ONE STOP COMMENT FORM

DRB Case No. 1001893

Project Name: TAPPE ADDN

Re: Preliminary/Final Plat Request for Lots 1 and 2, Block 0, Pappe Addition
Zone Atlas Page G-14-Z, Containing 0.4313 Acres

**PLAT OF
LOT 1-A, BLOCK 0
PAPPE ADDITION**

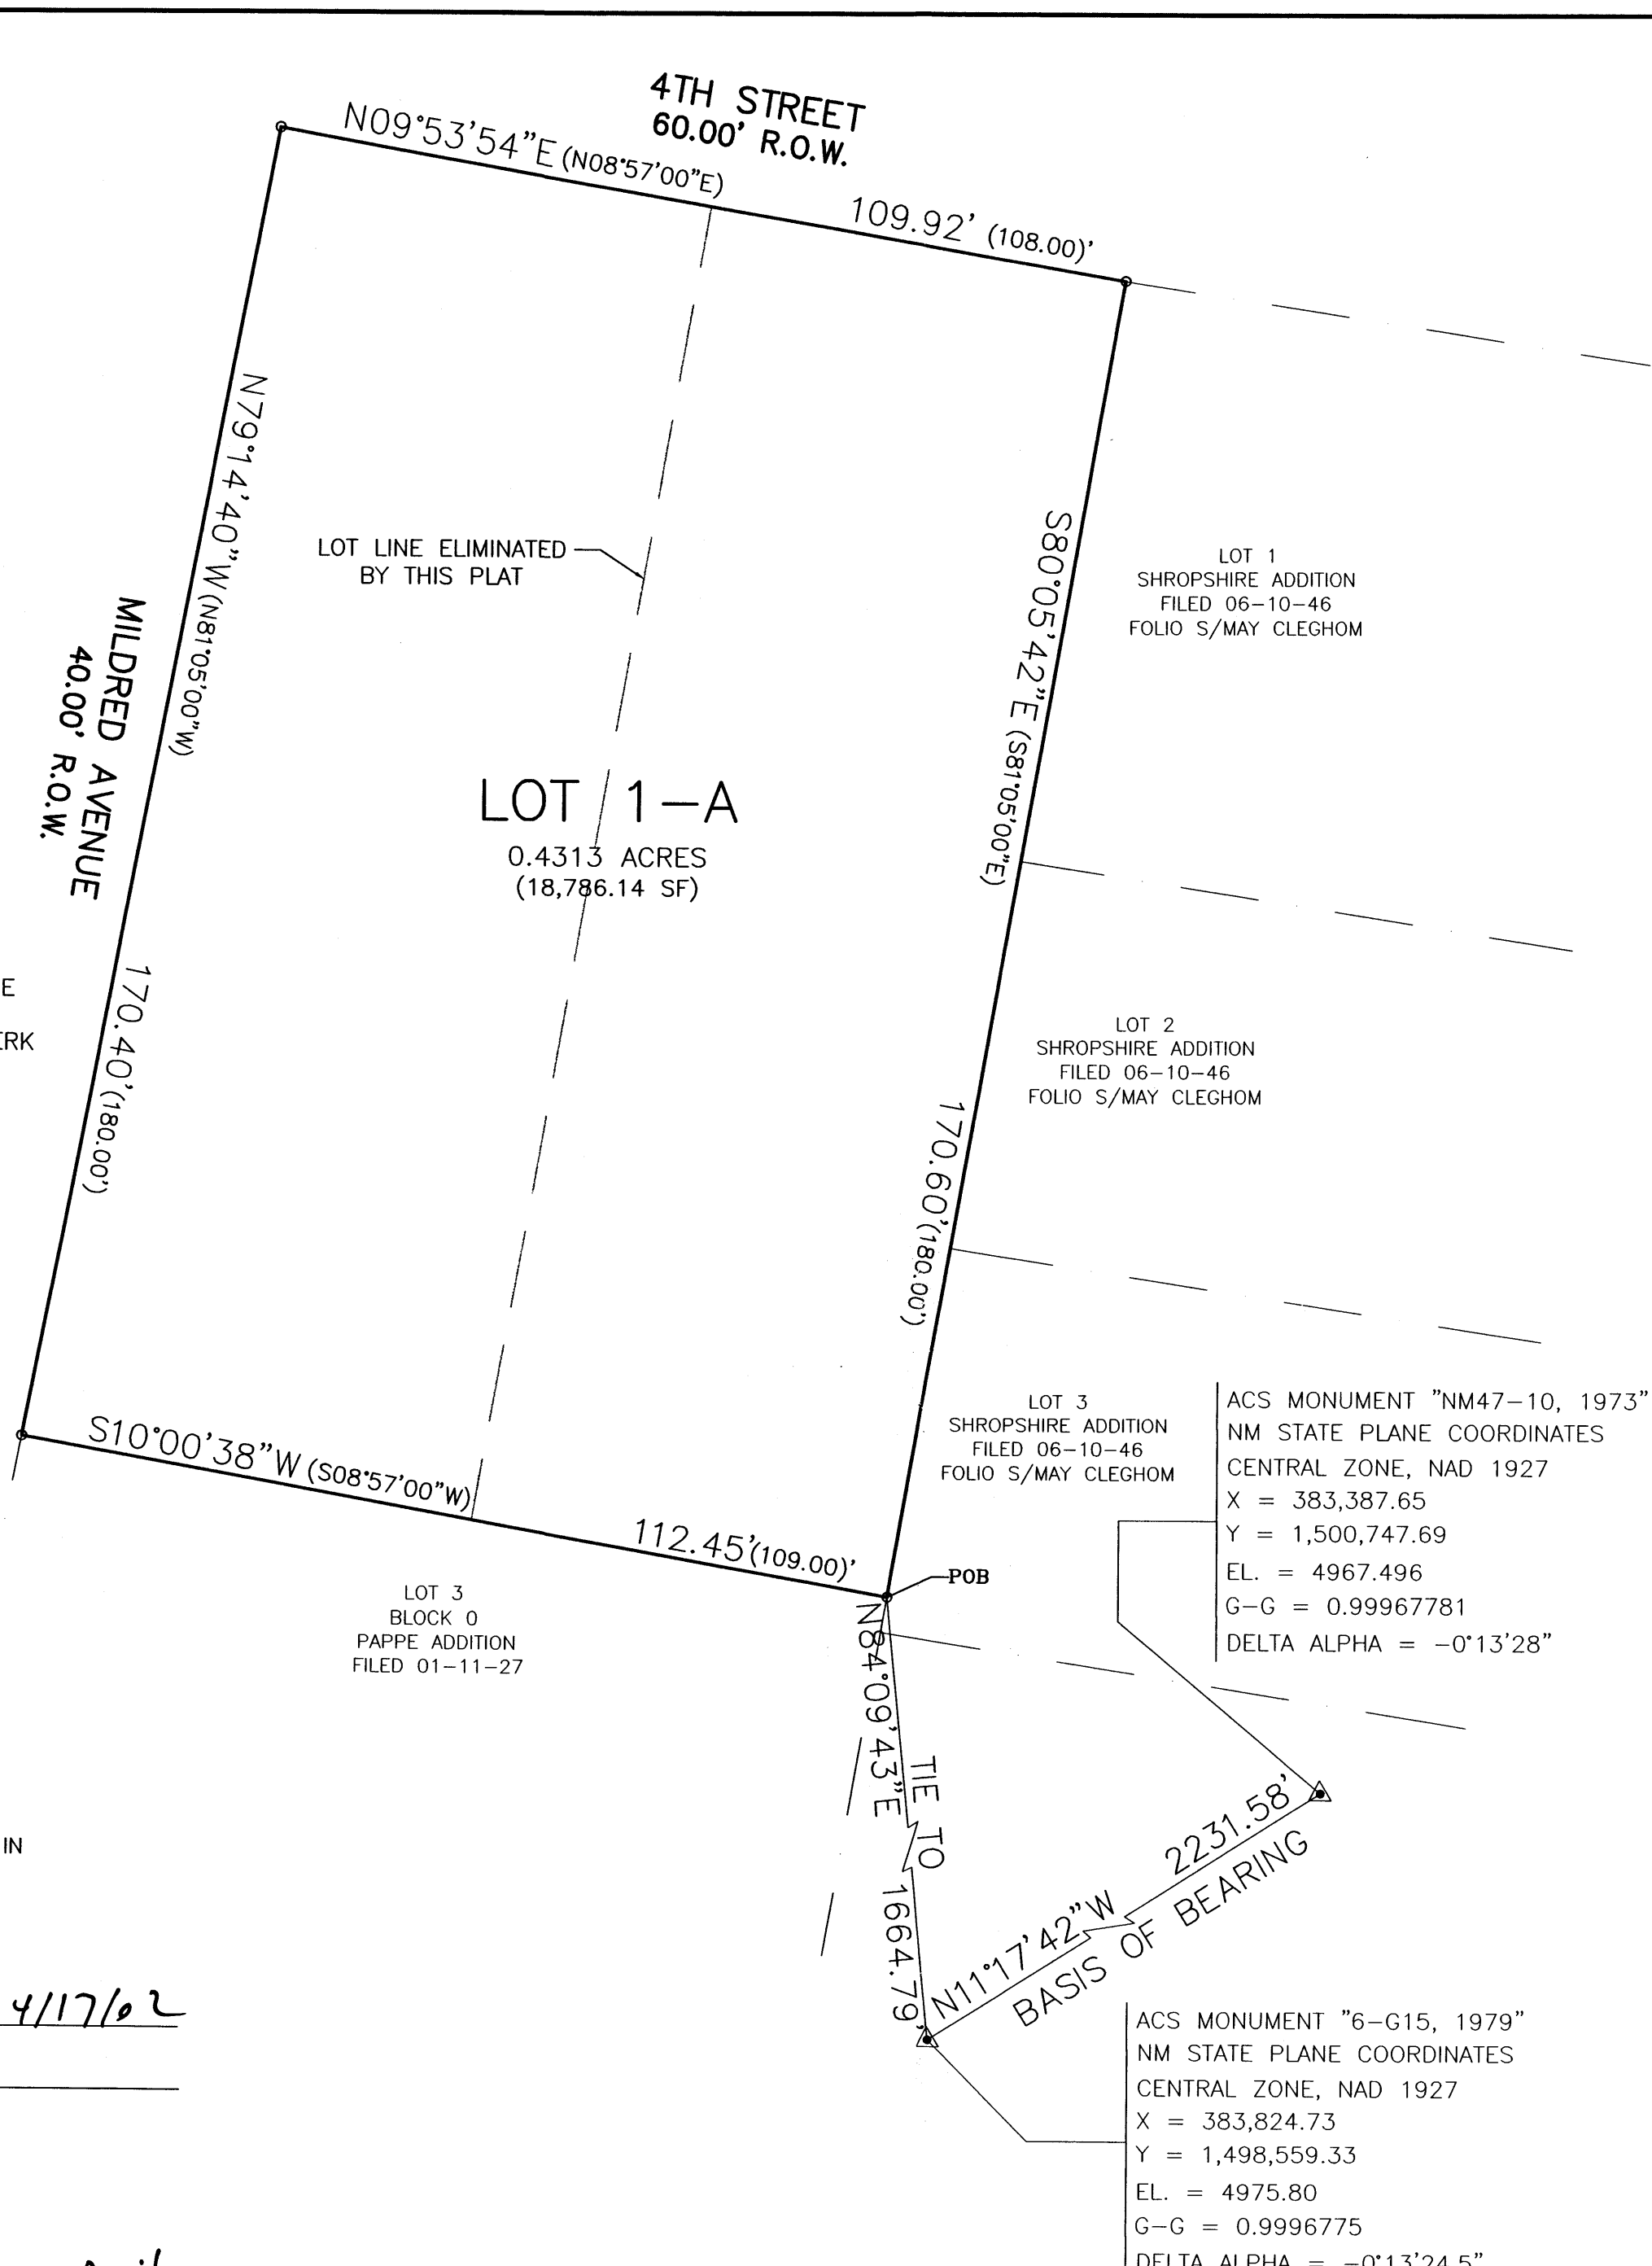
COMMENTS: Right-of-way dedication is needed at corner intersection of 4th St & Midway Ave
